Norfolk Boreas Offshore Wind Farm Applicant's Comments on Deadline 10 Submissions and Other Submissions (Tracked Changes)

Applicant: Norfolk Boreas Limited
Document Reference: ExA.ASR.D12.V2
Deadline 12

Date: May 2020
Revision: Version 2
Author: Royal HaskoningDHV

PZ  
PZ  
PZ  
PZ  
PZ

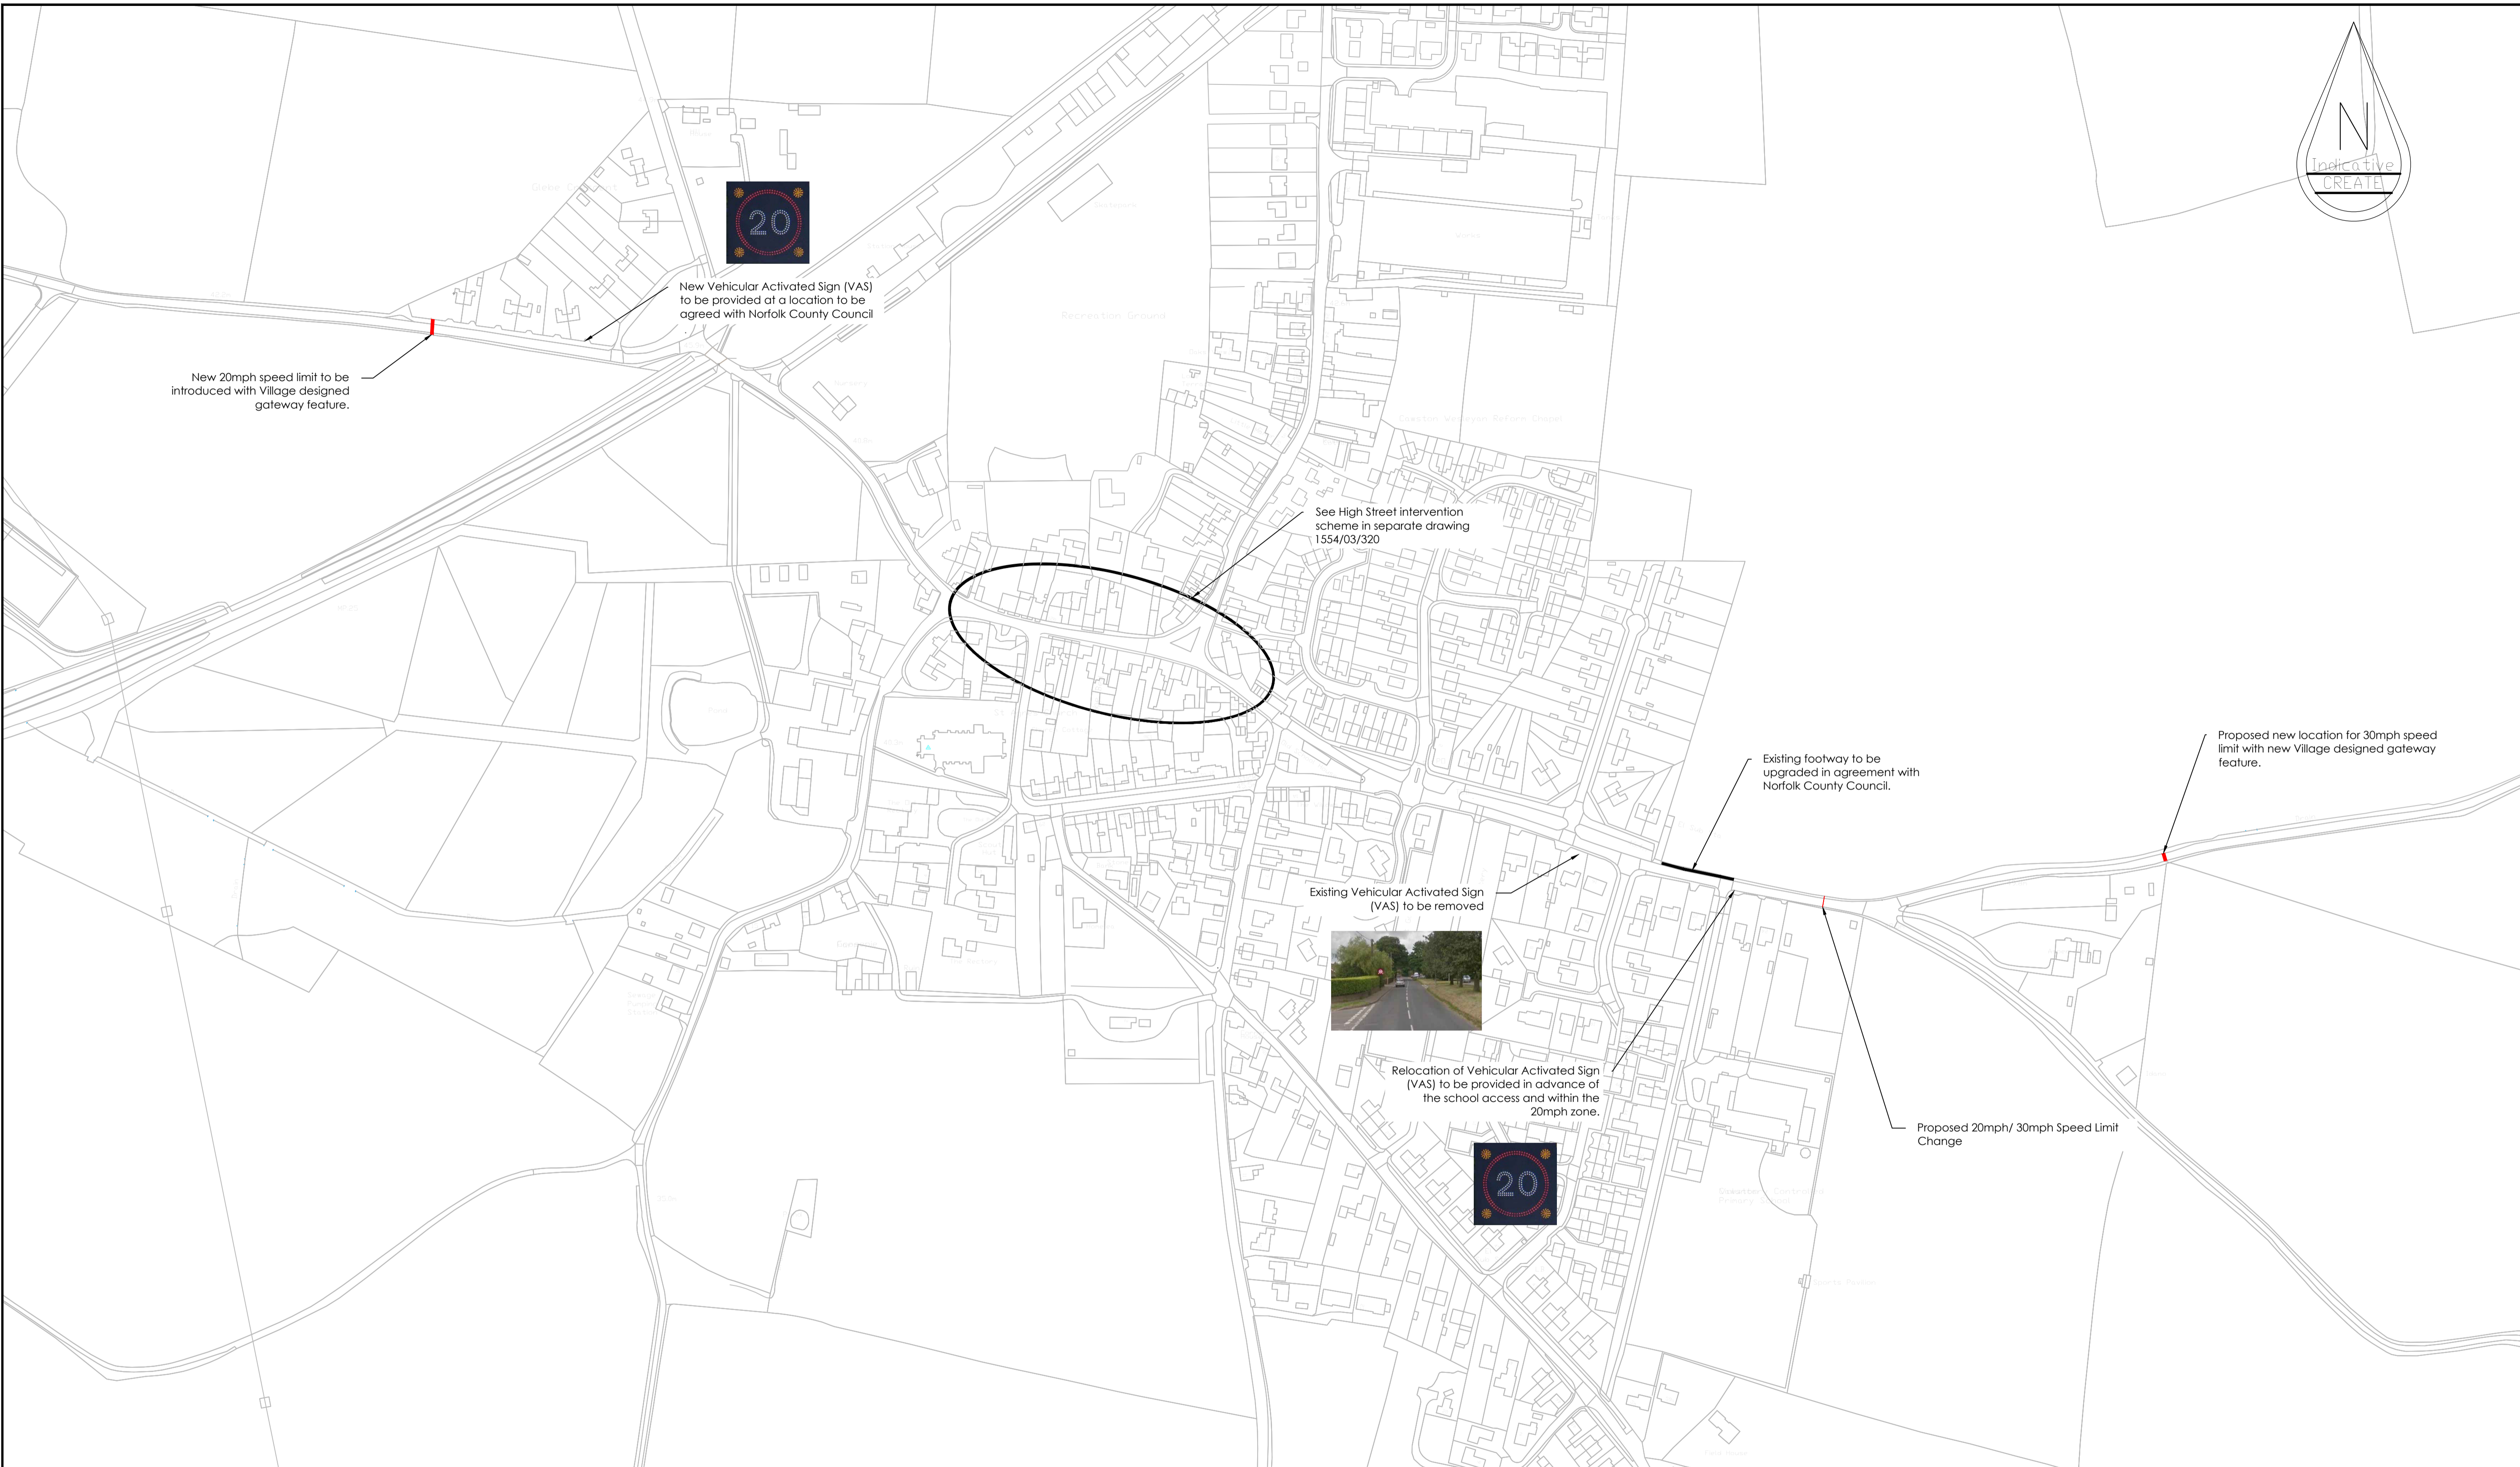
Summary of Submission	Applicant's Comments
<p>The additional width of vehicles from wing mirrors is not shown in the drawings and even in the areas designated for passing the additional width for two sets of wing mirrors and a safe passing distance between them is not evident.</p> <p>Cawston Parish Council views the proposed HIS to be flawed and impractical. For the scheme to have any hope of operating as designed a number of conditions need to be satisfied which include:</p> <ol style="list-style-type: none"> 1. The ability of all HGV drivers to be able to see oncoming traffic around corners on the bend at the railway bridge, on the bend by the Old Forge and on the bend close to White House Farm 2. A requirement for all HGVs, not only the Applicant's and/or Hornsea 3 project HGVs, to arrive at evenly spaced intervals 3. Where two HGVs approach from either East or West they must not have any other road traffic between so they can fit in the proposed system of "passing places". Any train of vehicles longer than the planned "passing space", which is designed for two HGV lengths, will obstruct passing manoeuvres and make gridlock more likely. <p>Norfolk County Council echoes some of CPC's concerns. The Applicant's Statement of Common Ground with NCC states that:</p> <p>NCC have raised a concern with regard to driver compliance, drivers may potentially fail to yield at pinch points causing traffic to back up, inducing unacceptable delays.</p> <p>In their letter of 27th April (REP8-036) NCC also reiterate their concerns that the HIS could fail</p> <ol style="list-style-type: none"> 1. If parking occurs outside the designated parking areas 2. Traffic fails to yield at the correct points 3. Or if traffic speeds are much higher than 20mph. <p>Residents of Cawston already see all three of these conditions on a daily basis, and our D6 submission (REP6-042) noted official Government sources showing that 20mph limits</p>	<p>Narrow footways</p> <p>[REP5-055] Revised Cawston Highway Intervention Scheme Road Safety Audit Decision Log ('RSA log') reports that the Road Safety Audit (RSA) recognises that the likelihood of pedestrian/vehicle conflicts has been reduced by the HIS key design principles of:</p> <ul style="list-style-type: none"> • Providing adequate road space for HGVs to traverse the High Street without the requirement to mount or project over the pavement; • Protecting adequate road space for the HGV routes with the introduction of formal parking controls; • Advance sign warning of 'pinch points'; and • The introduction of a mandatory 20mph limit. <p>The RSA notes there may be a residual perceived risk to pedestrians and makes the following recommendations:</p> <ul style="list-style-type: none"> • Introduce measures to highlight the presence of pedestrians within the area; • Introduce road markings and 20mph signage at the gateways allowing for maximum impact and awareness; • Provide maximum footway area, by attaching all signs to existing street furniture where possible and introducing any new signposts to the back of the footway, reducing footway clutter. • Review the compliance of drivers following the introduction of the reduced speed limits and introduce further measures if necessary. <p>The Applicant has accepted all of these recommendations and has incorporated them into the finalised HIS design (detailed in the OTMP [REP10-016]. The Applicant therefore reiterates the conclusion of the RSA log [REP5-055]:</p> <p><i>"Following the evaluation of the key effects that are likely to influence pedestrian risk it is concluded that the likelihood and severity are low and</i></p>

Summary of Submission	Applicant's Comments
	<p>a 20mph speed limit to enable HGV drivers to safely react to the highway environment and 'yield' to oncoming HGVs as required.</p> <p>The HIS design has been informed by a full topographical survey and demonstrates the swept path simulation of the largest UK standard HGV; a 44t articulated tractor and semi-trailer, 2.55m wide trailer, 2.49m cab width and 0.25m wide wing mirrors.</p> <p>In respect of HGV arrival/regulation, the HIS scheme design has been developed to accommodate an even arrival profile for the Project's HGVs (the management of which is secured in the OTMP [REP10-016]) and a random arrival pattern for non-Project HGVs.</p> <p>An intensive monitoring regime and further driver compliance intervention measures were introduced at Deadline 8 in the Outline Traffic Management Plan (V4) [REP8-008] to accommodate the RSA recommendations. In addition, in response to NCC's request for clarification, the text has been refined, as agreed with NCC, and is included in the OTMP (Version 5) submitted at Deadline 10 [REP10-016]. Agreement is confirmed in both the final Statement of Common Ground with Norfolk County Council (Version 3) [REP9-015] and the Applicant's Joint Final Position Statement with Norfolk County Council Highway Intervention Scheme, Cawston (ExA.AS-1.D11.V1) to be submitted at Deadline 11. The range of measures to enable targeted intervention on validation of a driver compliance issue are as follows:</p> <ul style="list-style-type: none"> • Applying the OTMP 'breach' corrective process identified in Section 5.4 and 5.5 to the supply chain; • Further hazard signing; • Introducing mandatory priority 'give-way'; • Increased parking enforcement; • A reduction in the cumulative HGV cap (239 HGV movements) by ensuring Norfolk Boreas and Hornsea Project Three traffic demand does not overlap; and • Incrementally reducing the volume of traffic passing through Cawston from 239 HGV movements through targeted intervention
